**RE: Skyview West Warehouse Office  
7110 Central Ave SW  
30-Day Temporary CO Extension- Approved  
Engineer's Stamp Date: 10/21/24  
Engineer's Certification Date: 10/2/25  
Hydrology File: K10D070  
Case # HYDR-2025-00356**

Based on the Engineer's Drainage Certification received 10/02/2025 and site visit on 10/14/2025, this letter serves as a conditional approval from Hydrology Section for a 30 day extension of the **Temporary Certificate of Occupancy** for the Skyview West Warehouse located at 7110 Central Ave SW to be issued by the Building and Safety Division. **This extension is through February 15, 2026.** The following comment needs to be addressed prior to acceptance for Permanent C.O. of the above referenced project:

ENGINEER'S SEAL RONALD R. BOHANNAN P.E. #7868	SKYVIEW WEST ALBUQUERQUE, NM	DRAWN BY pm
	GRADING PLAN	DATE 10-21-24
 TERRA WEST, LLC 5571 MIDWAY PARK PL NE ALBUQUERQUE, NEW MEXICO 87109 (505) 858-3100 www.tierrawestllc.com	SHEET # GR-1	JOB # 2023062

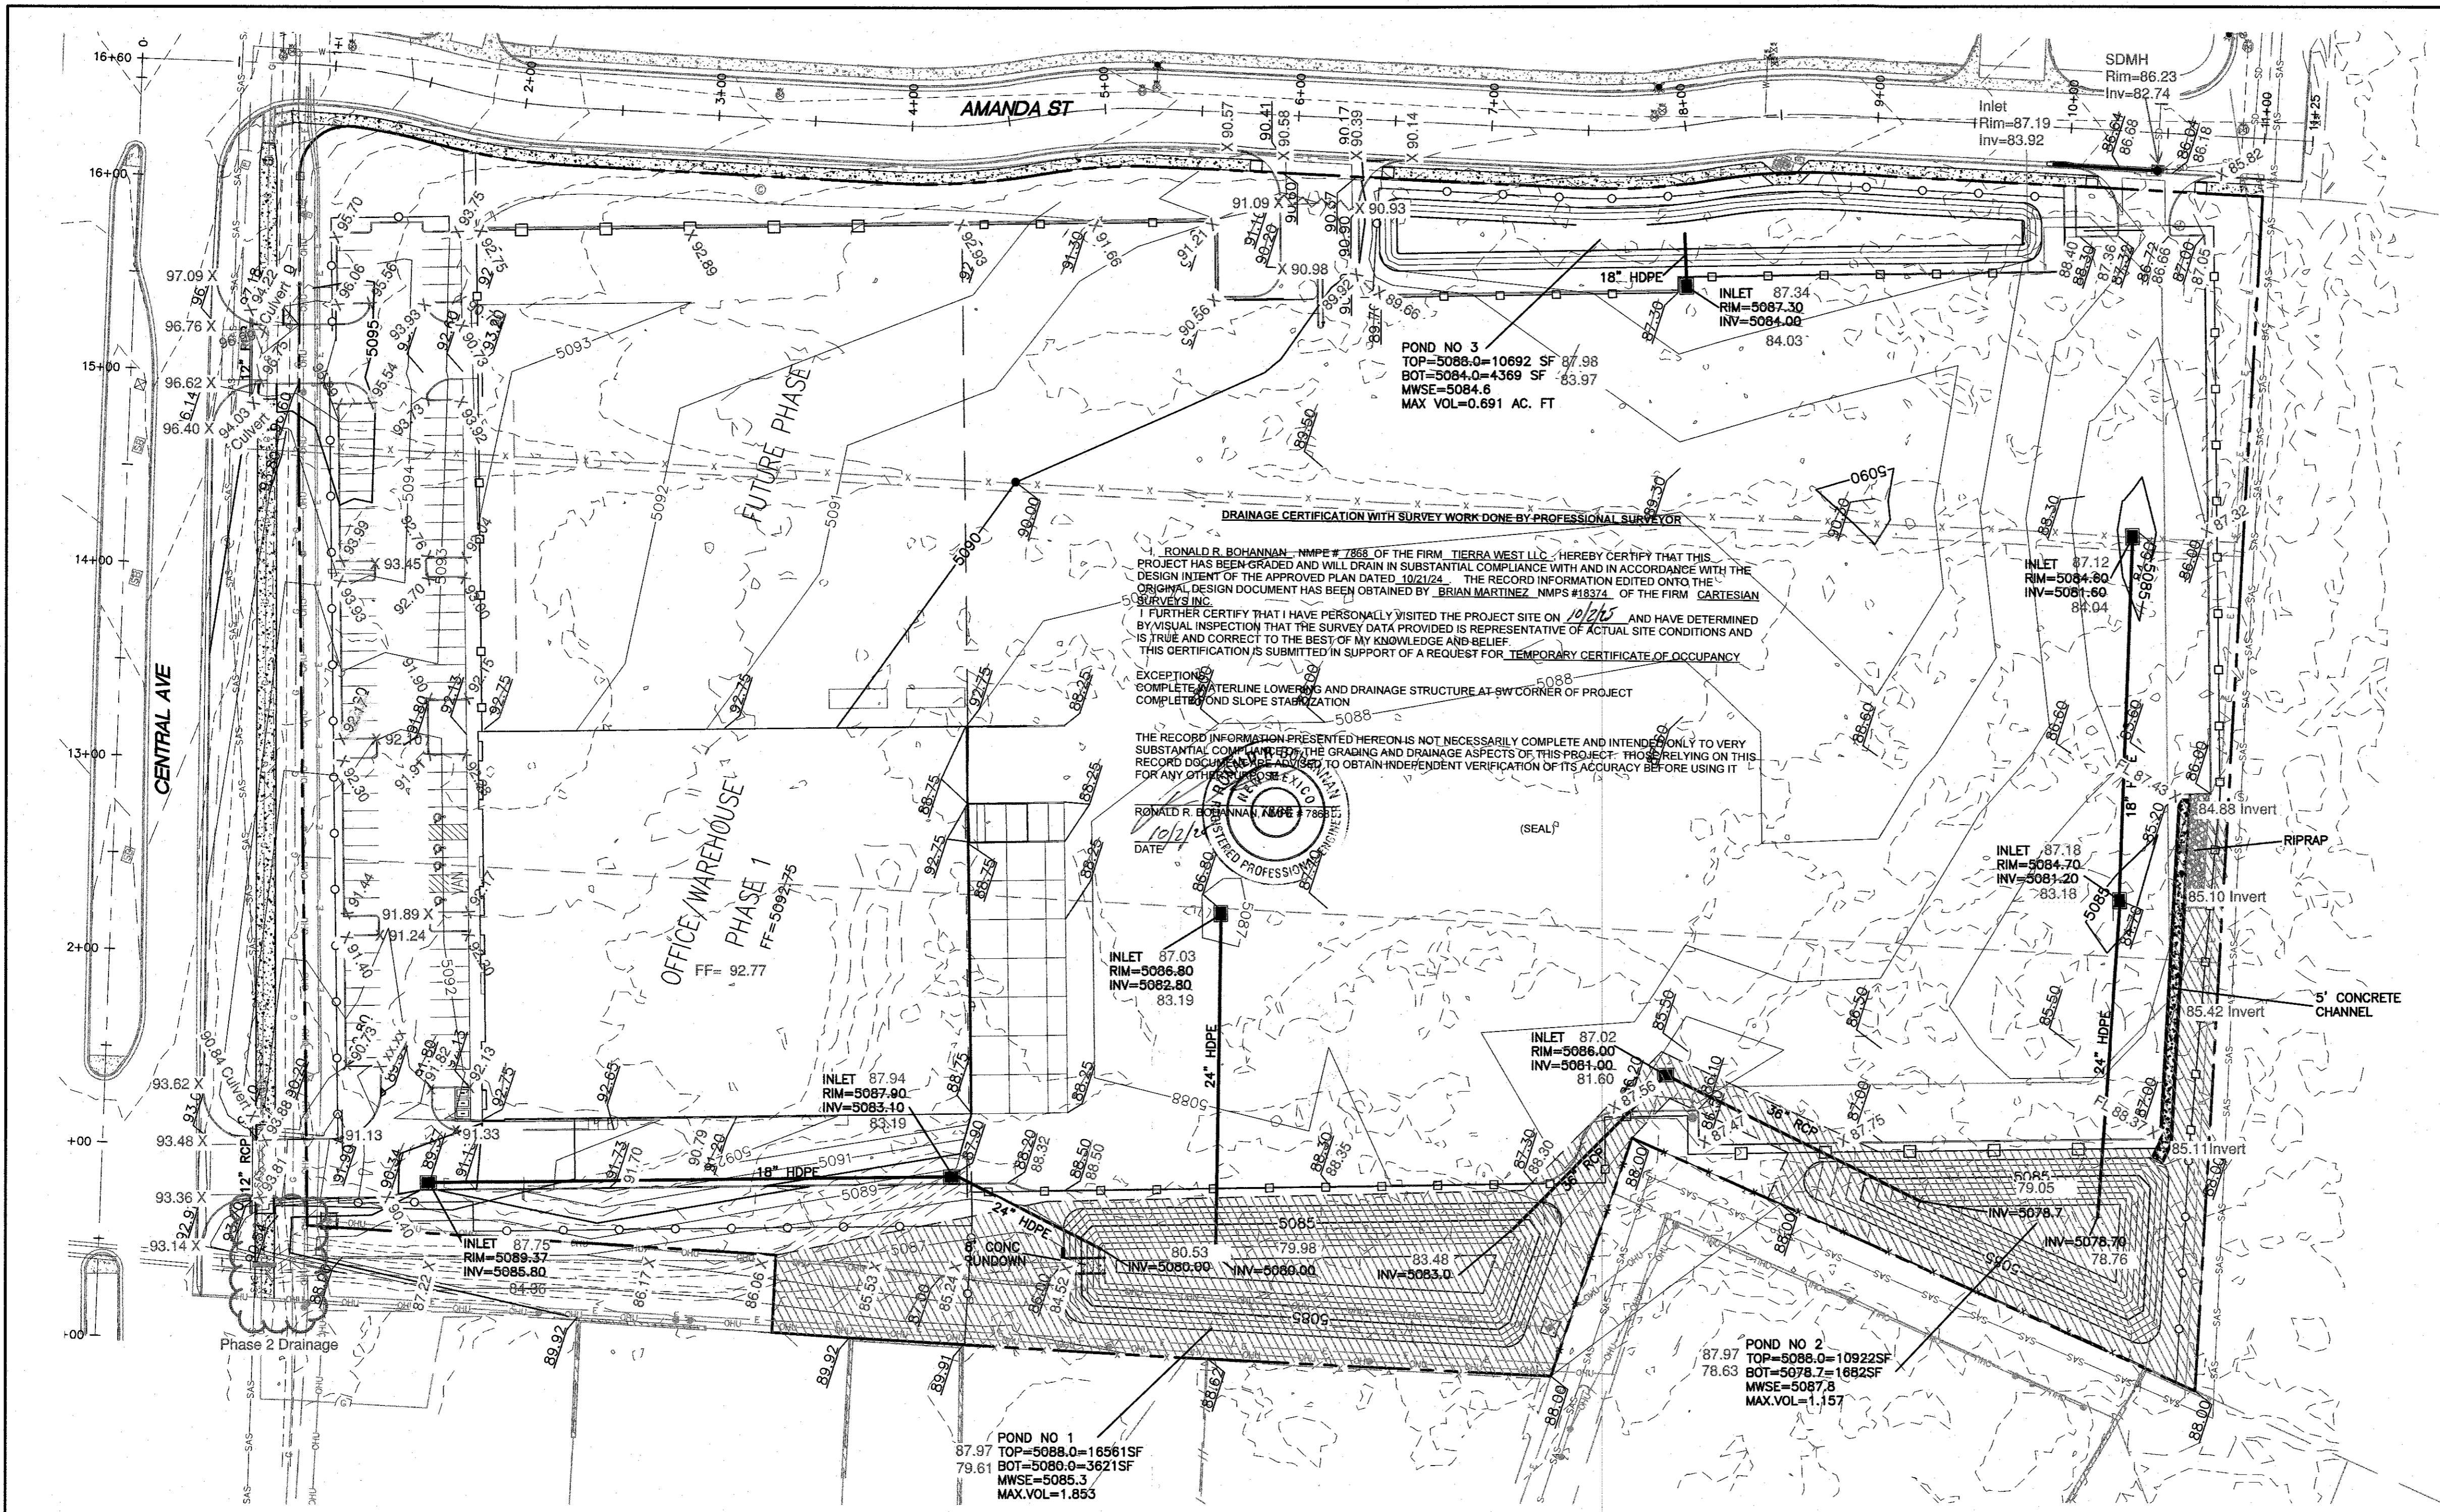
1. Complete the construction of the drainage structure NW corner of the project.
